EMBREY BUILDERS, LLC.

RFI

RFI #: 115
Date: 5/14/2012
Job: EB-02 Keller Springs Lofts
Phone: 877-777-5115

Subject: HVAC Supply Duct and Return Air Duct Locations

SHEET NUMBER
M-2.1
E1 &
A1 UNIT
MECHANICAL

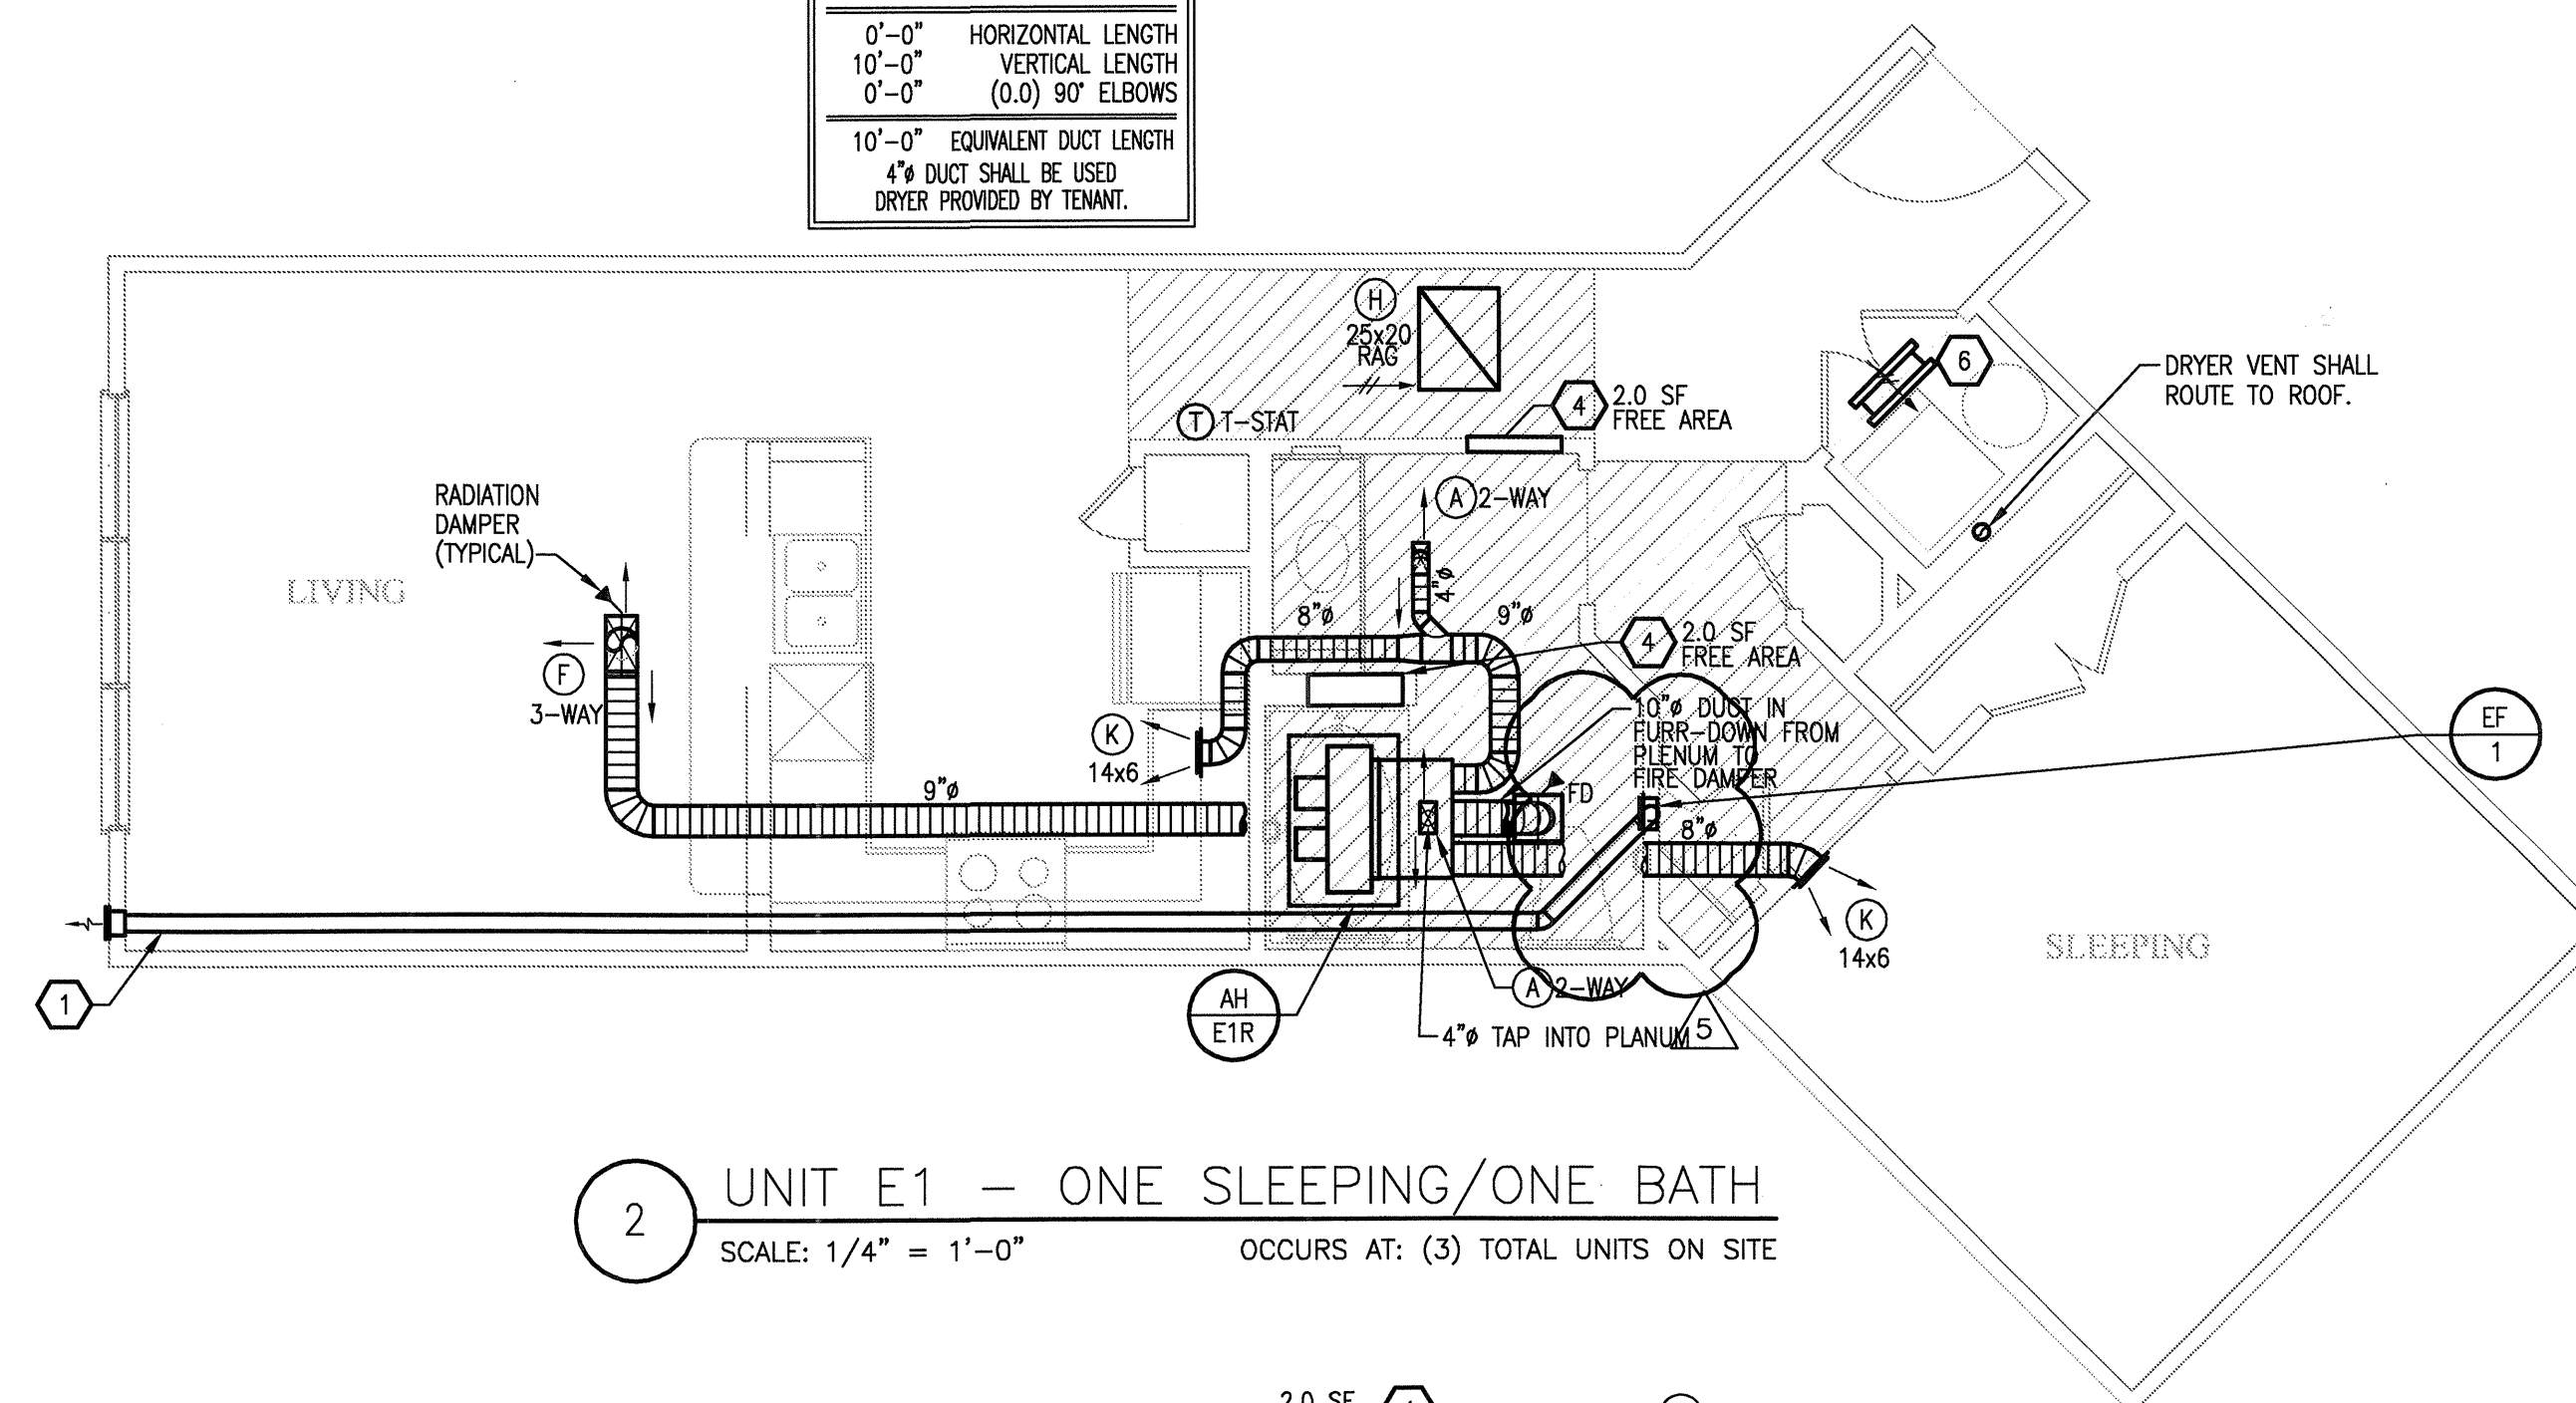
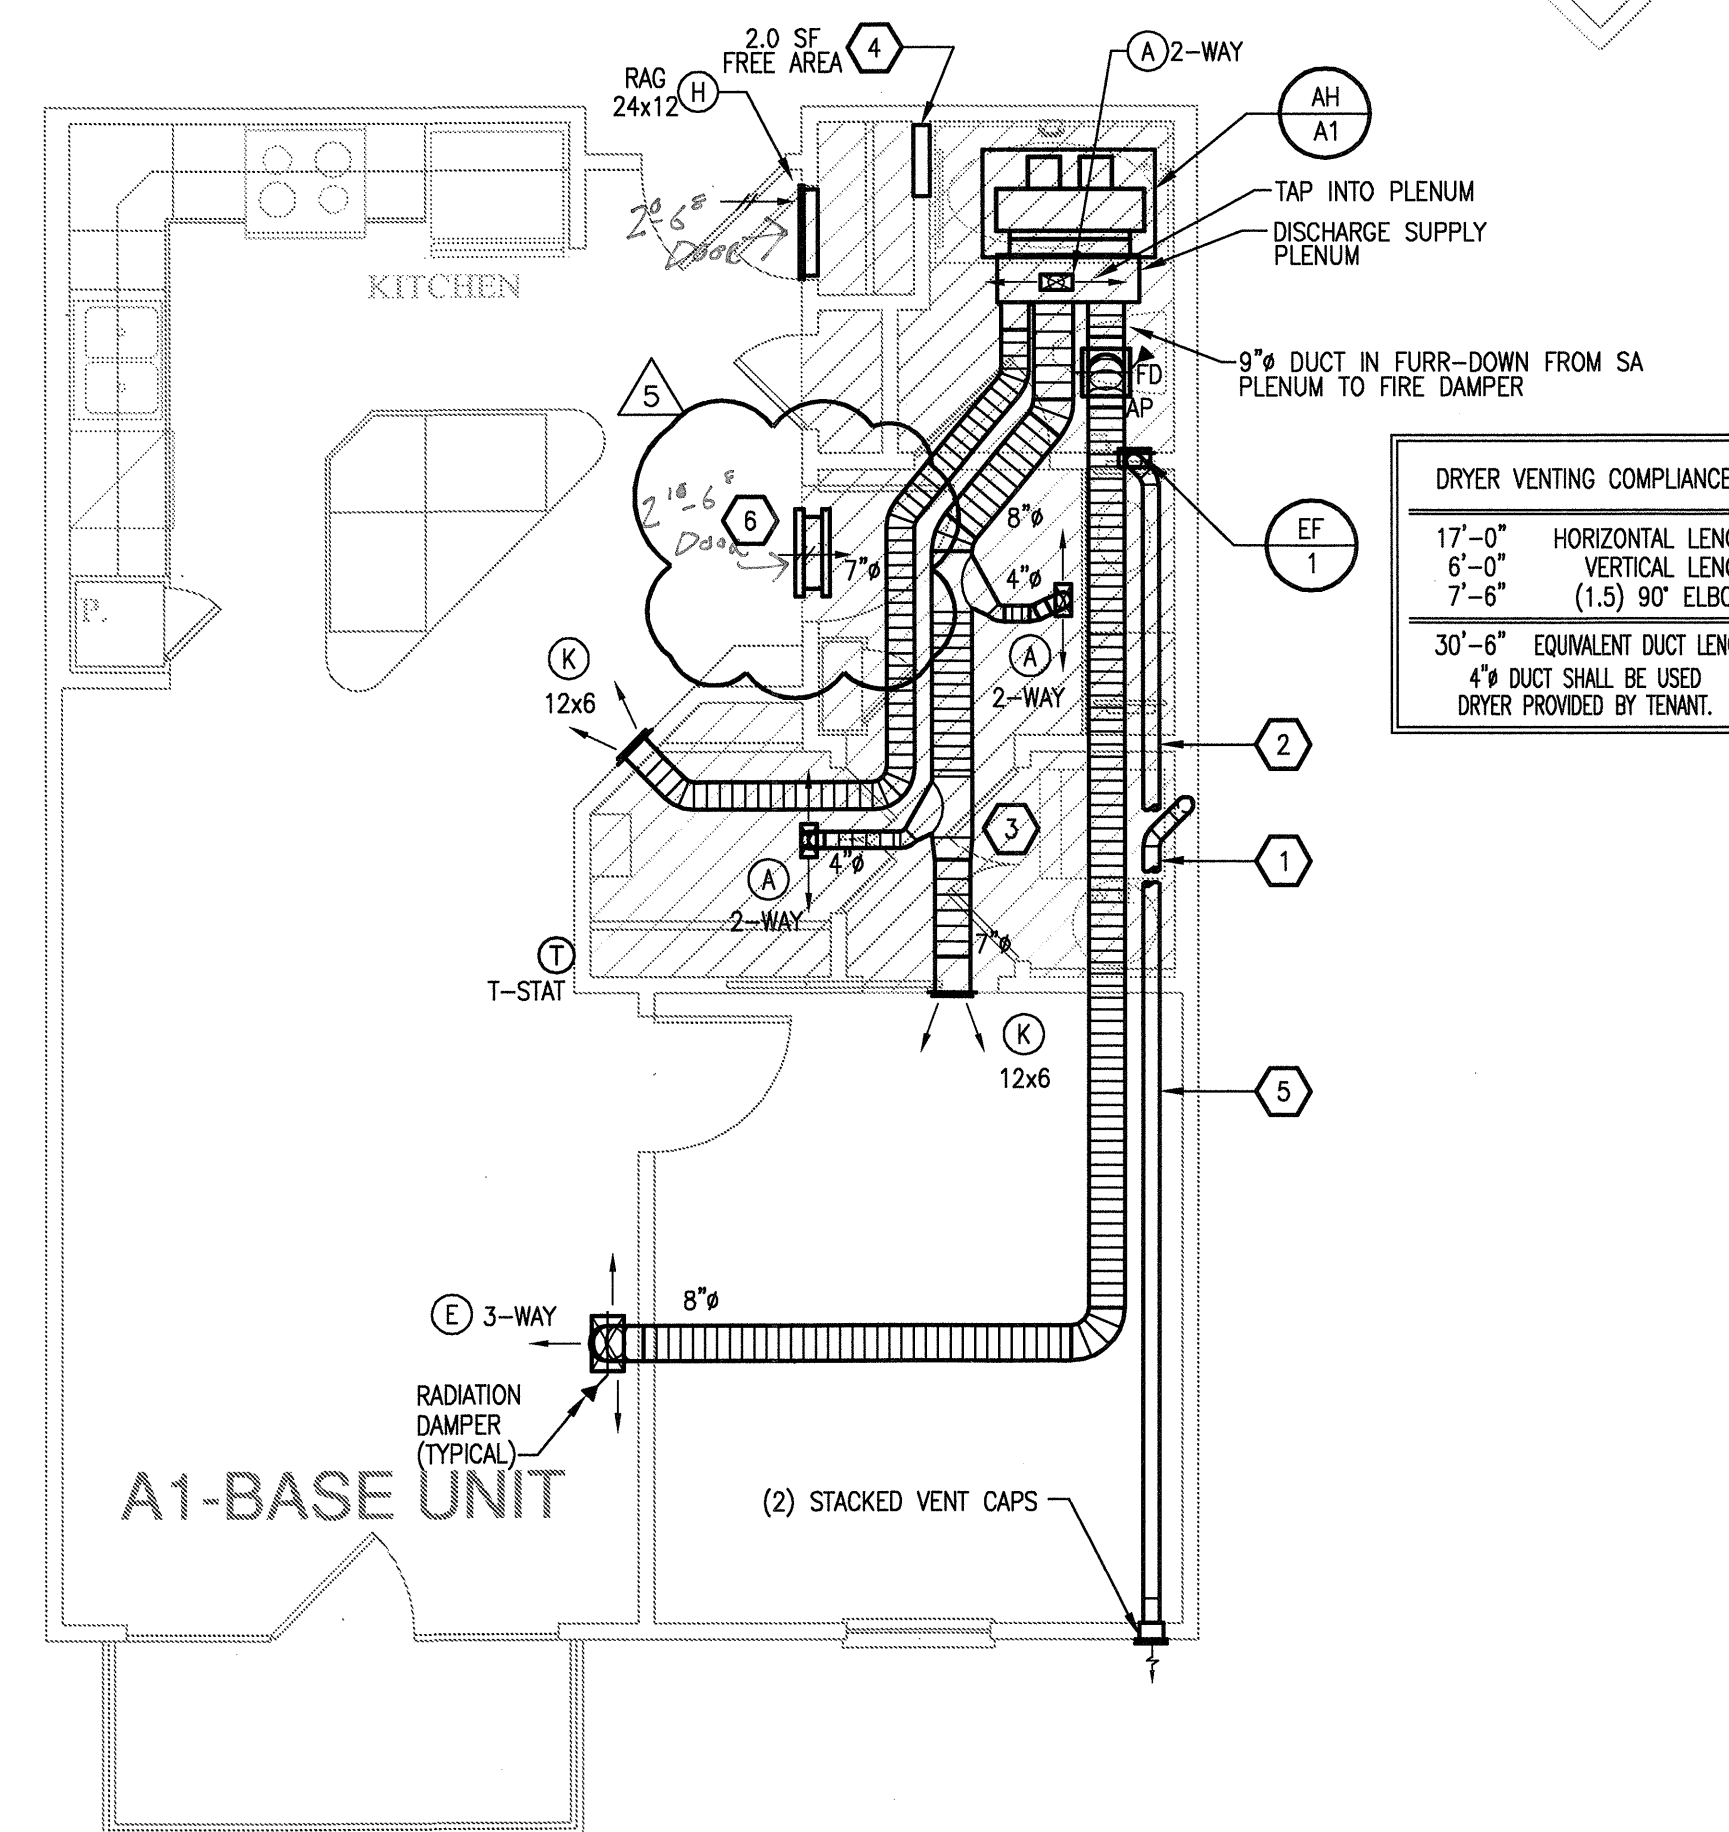
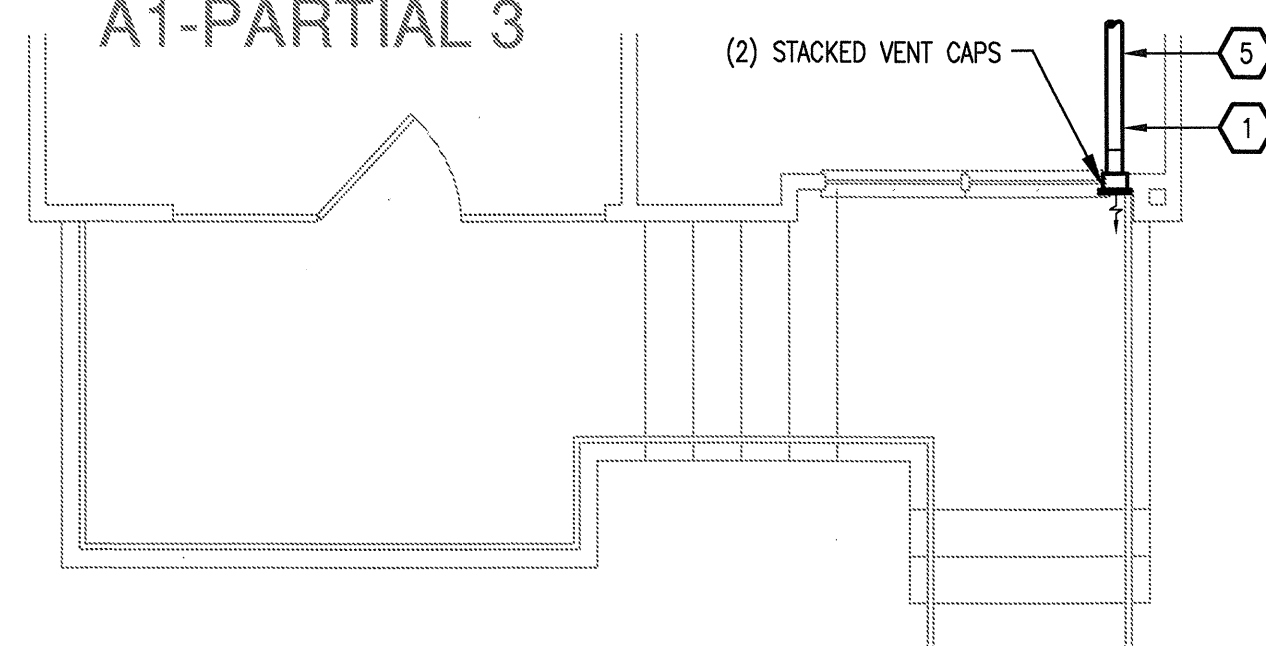
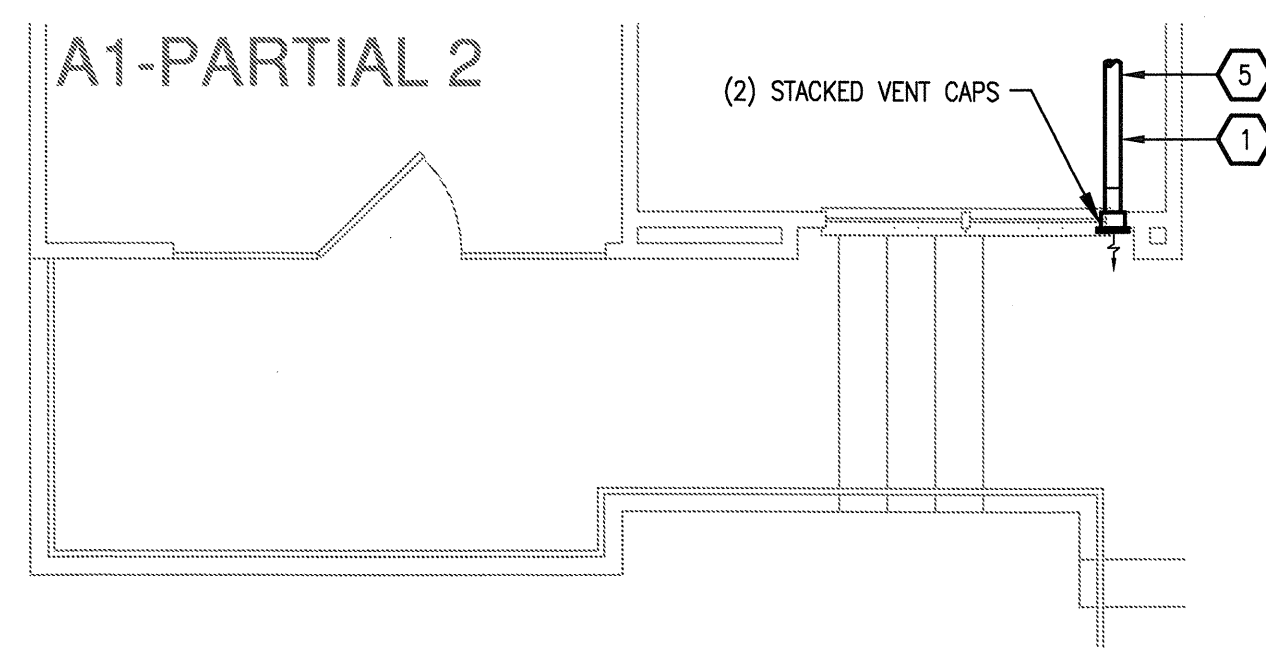
Request: **Date Required:** 5/22/2012
In the A1, A2, A4 and B2 unit types, there are either supply ducts or return air ducts terminating in a load bearing wall. Please provide a way to get around this issue.

Refer question to Architect and/or Mechanical Engineer for additional requirements necessary for penetrating a load-bearing wall.

Provide a type A header where duct penetration will not fit between the stud wall framing.
